## Department of Planning and Environment

**Subject: Request for Advice: Greenwich Hospital Redevelopment - Detailed Design (SSD-13619238)**

**Attachment A:** EHG Comments for Greenwich Hospital Redevelopment - Detailed Design (SSD-13619238)

Appendix E - 3 Existing 1% AEP Peak Velocity

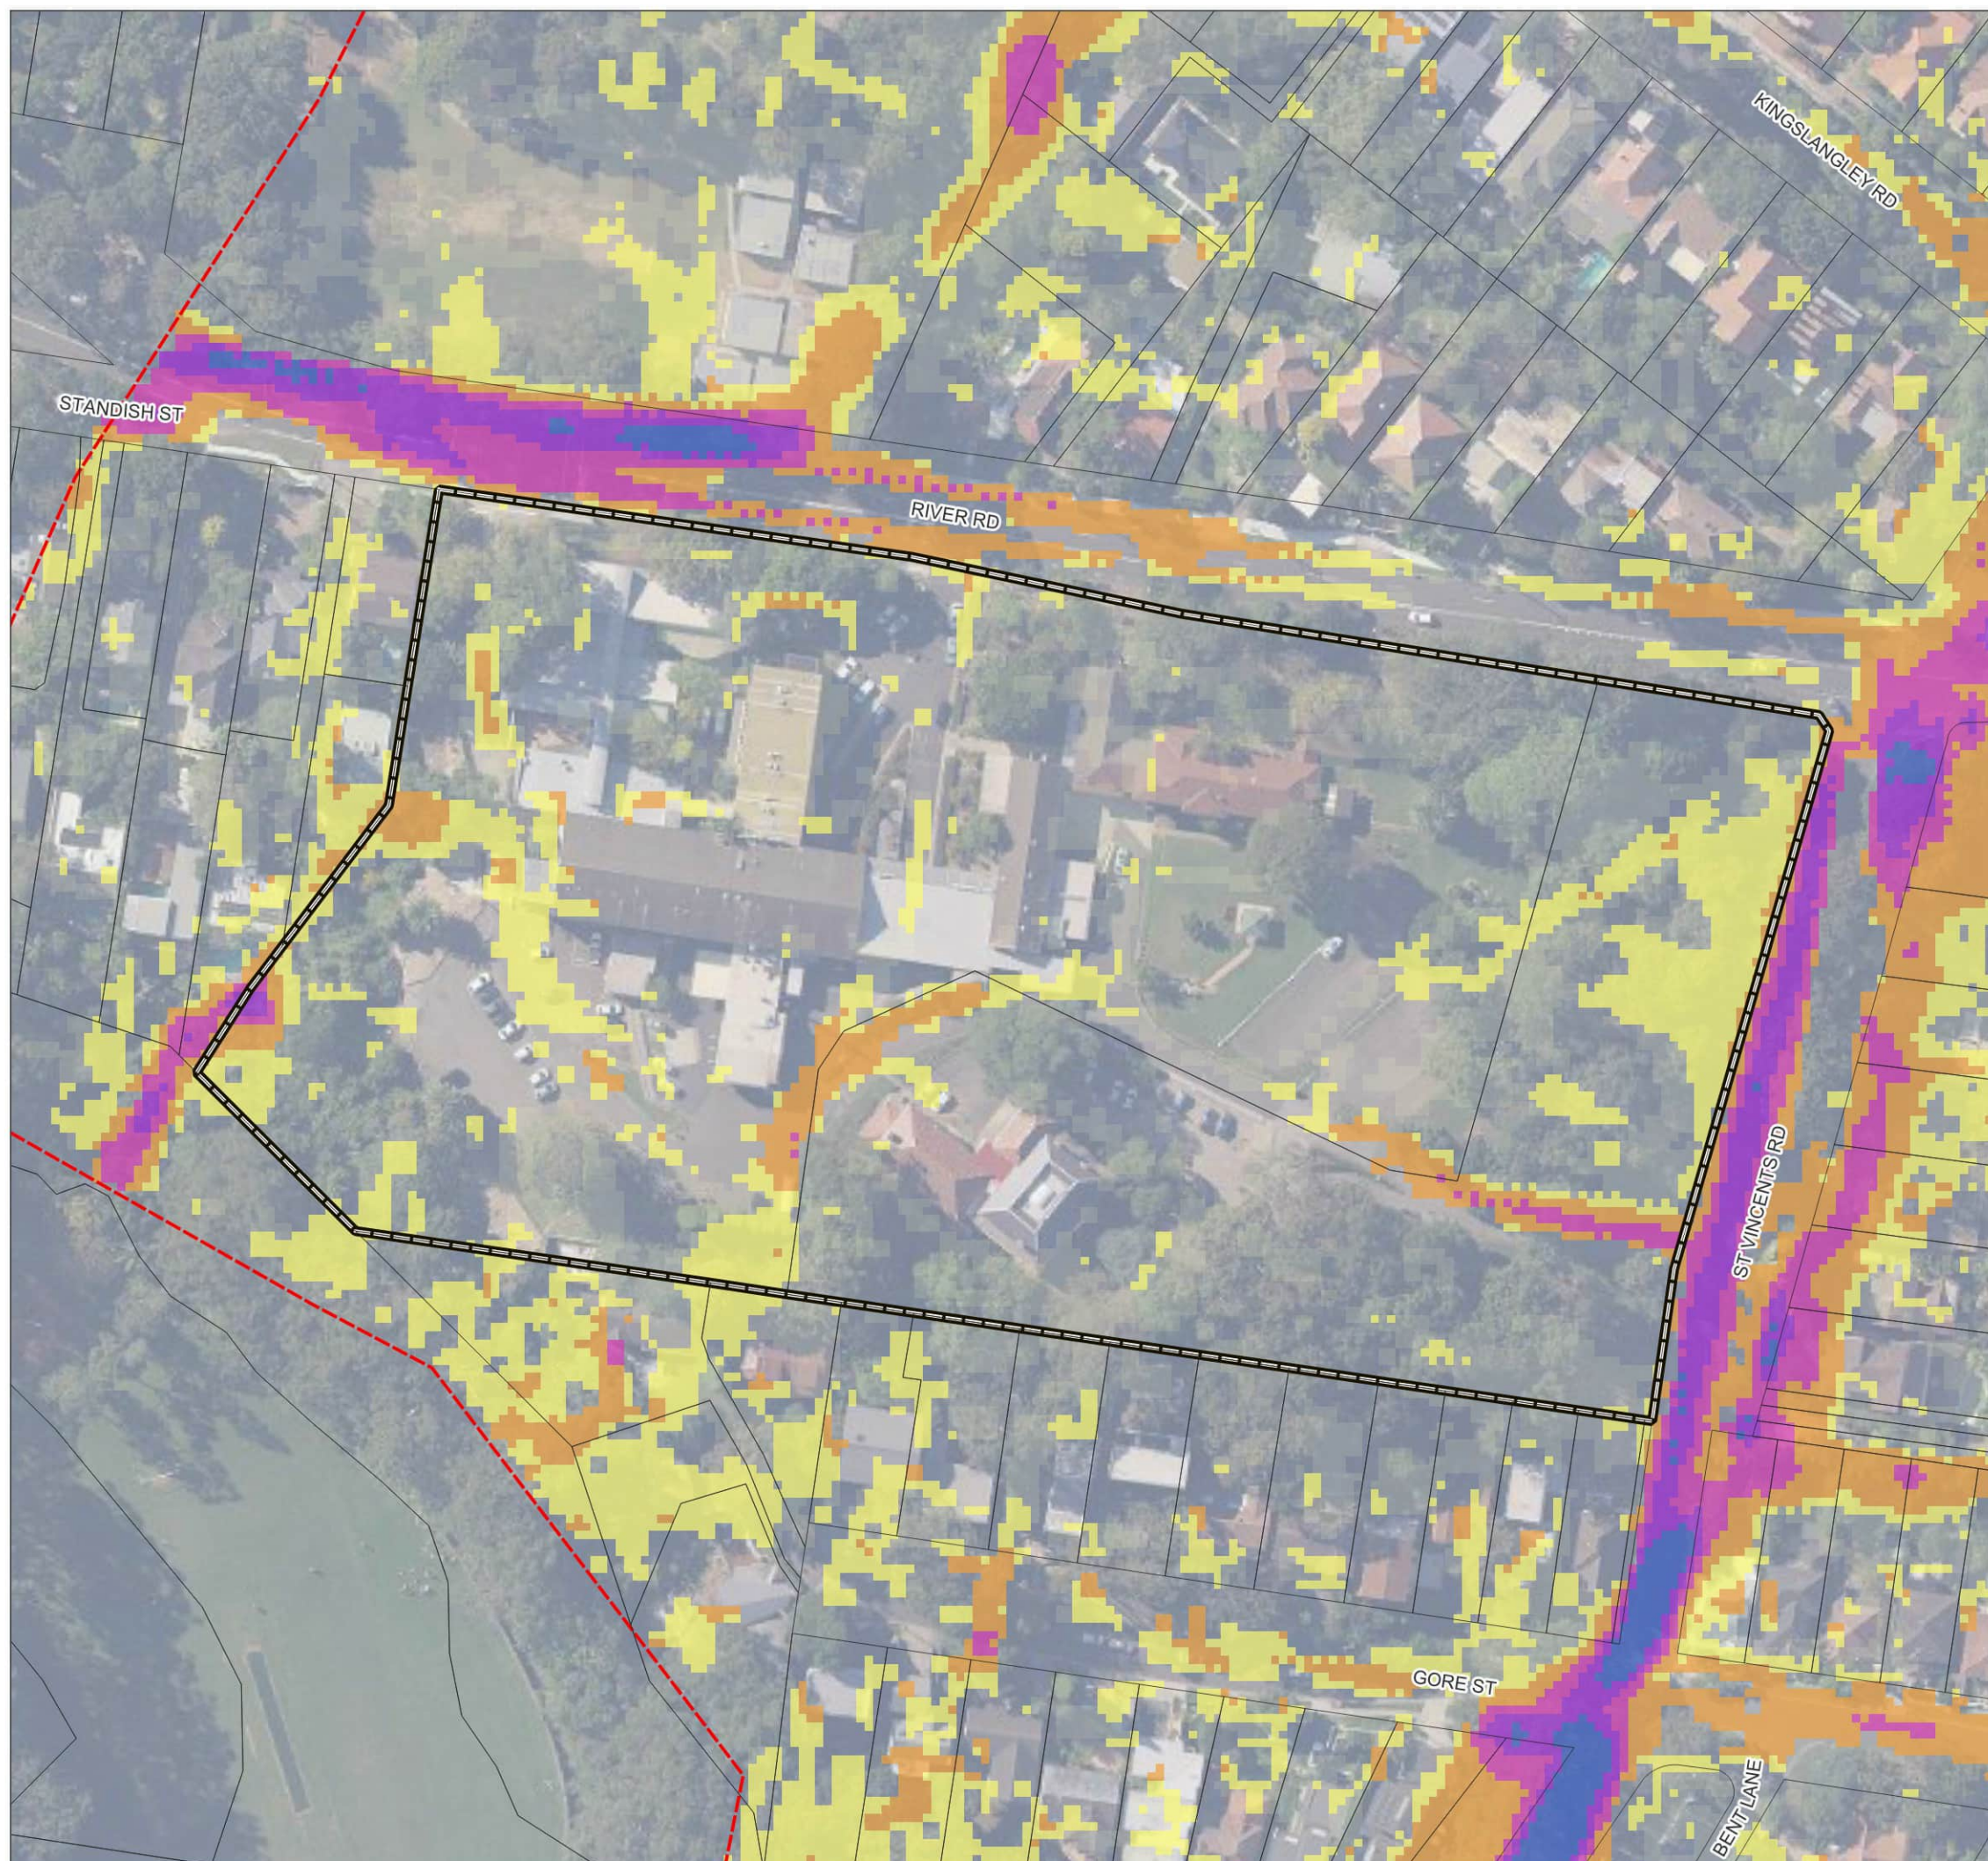
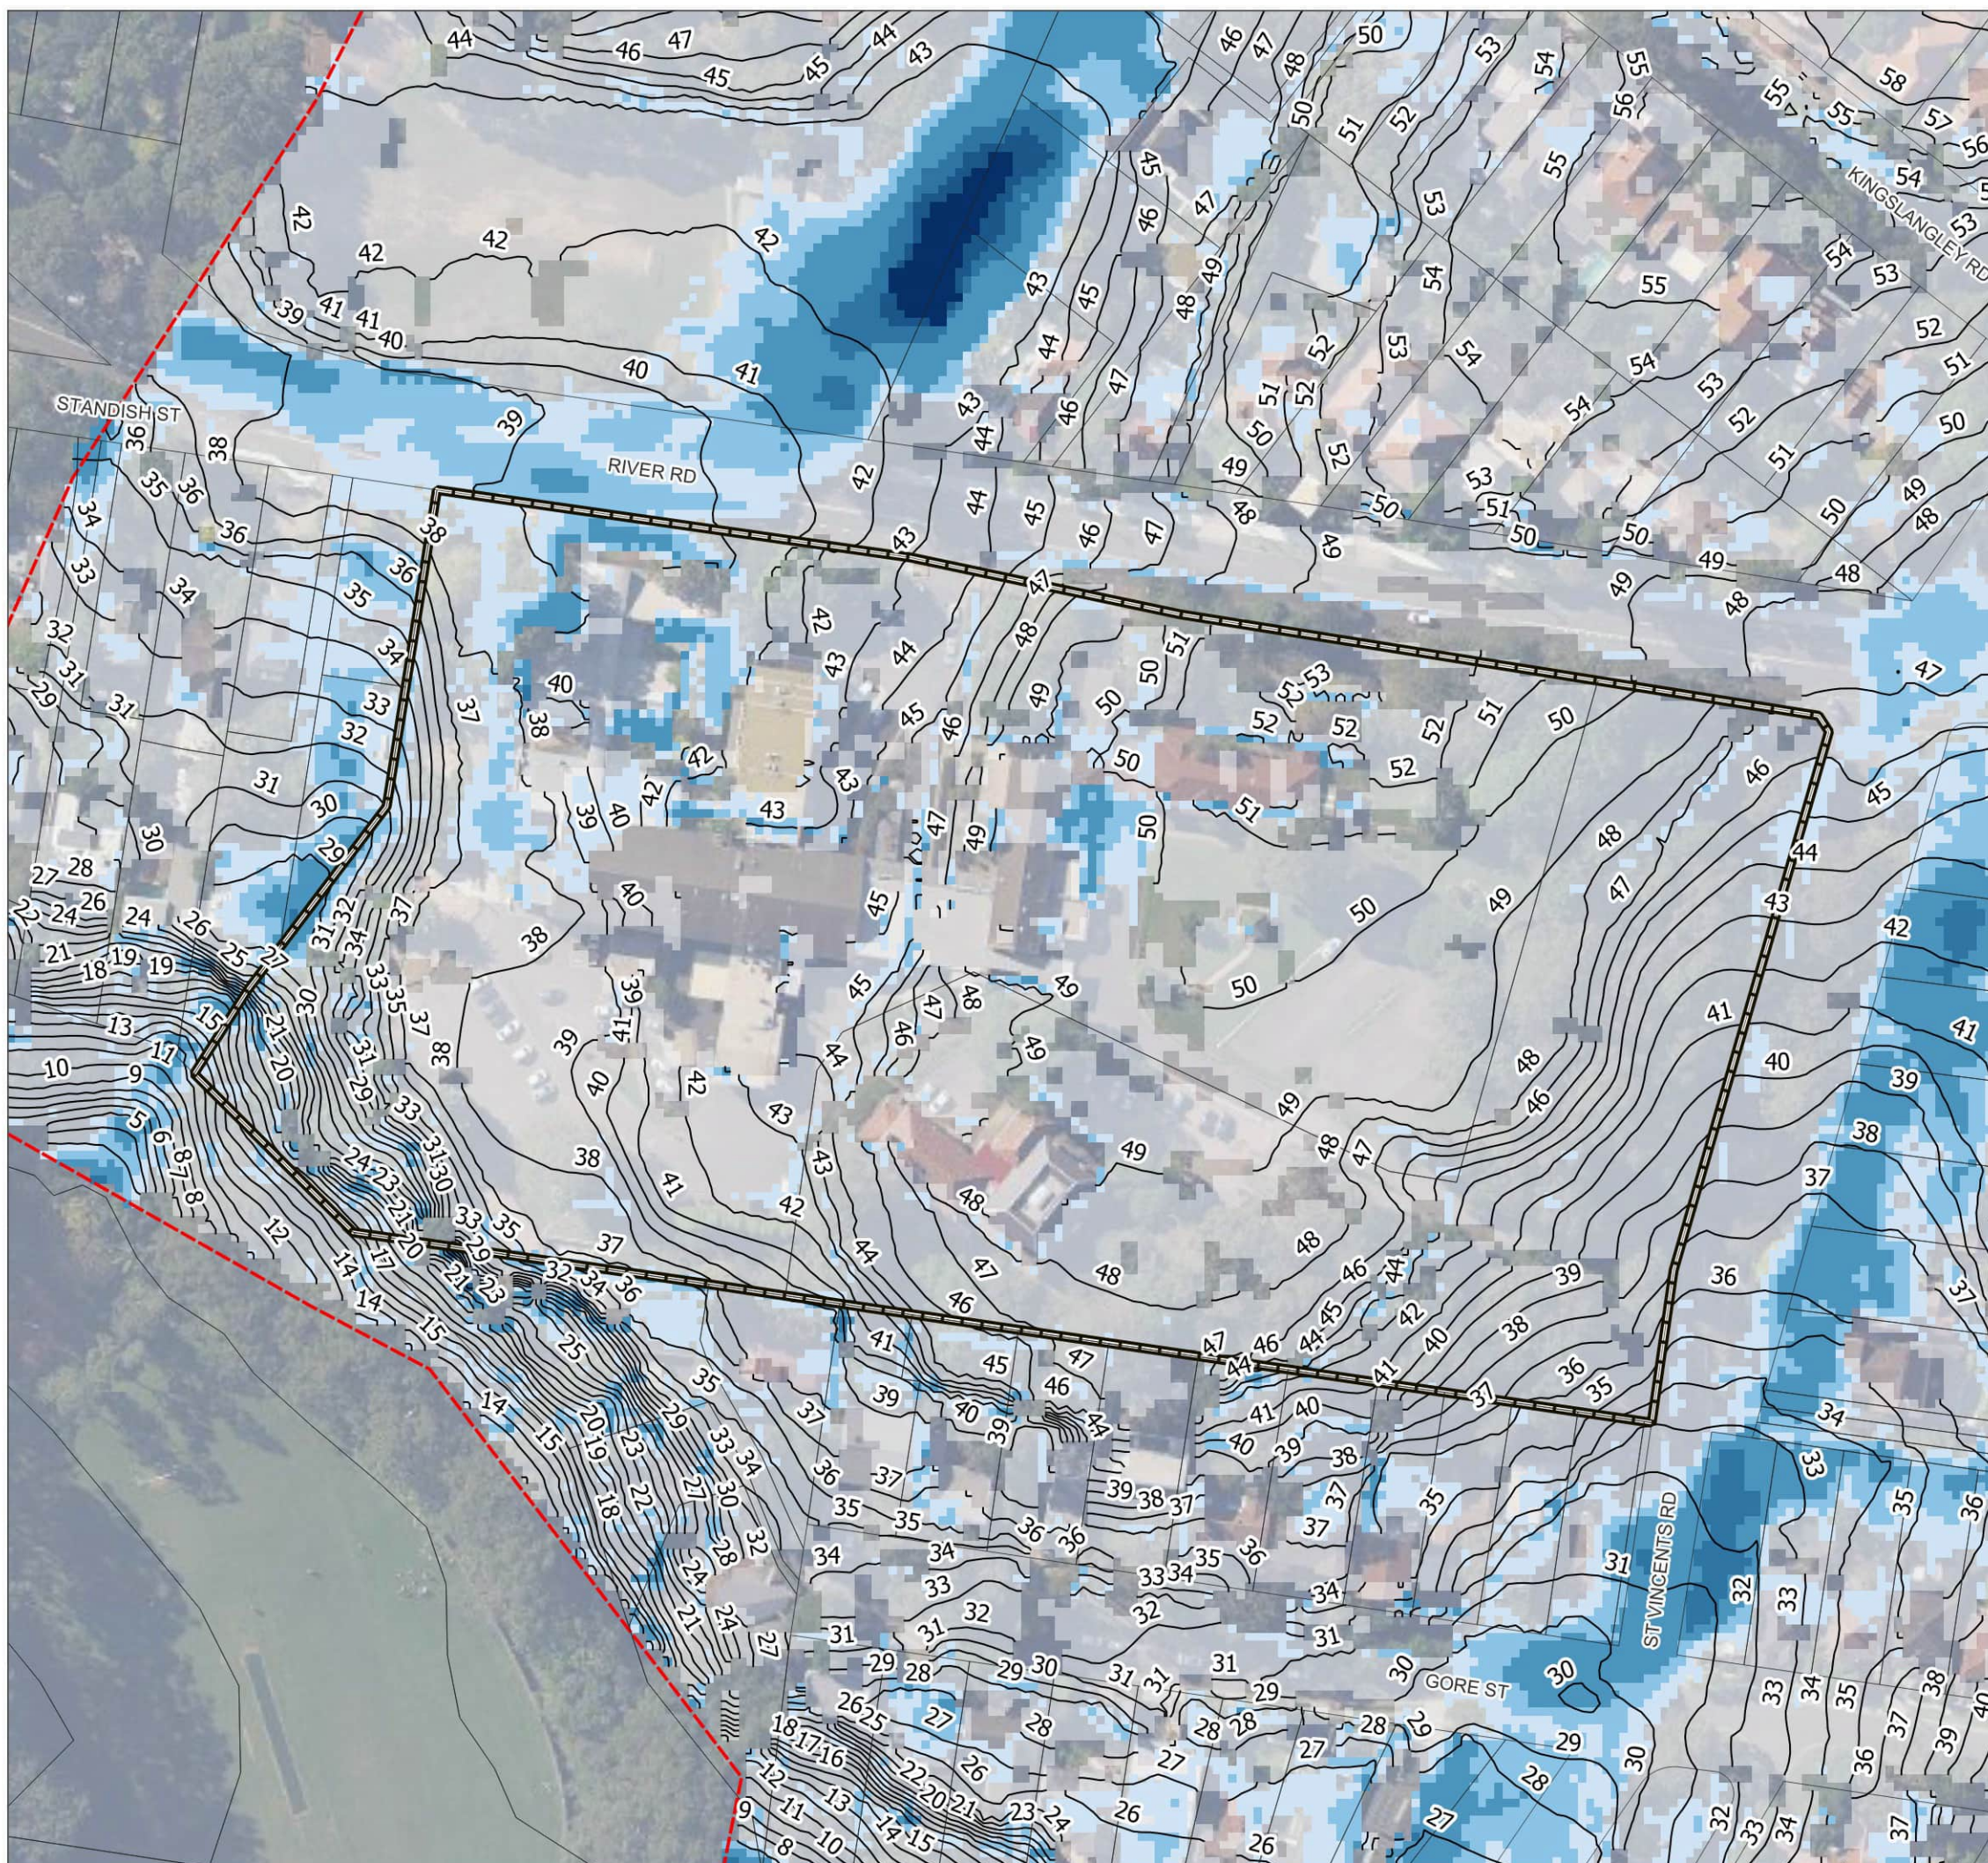
EHG also notes that the flood assessment - Appendix E provided a map of the 1% flood impact assessment, but there is no such map for the probable maximum flood (PMF) event. This mapping should be provided.
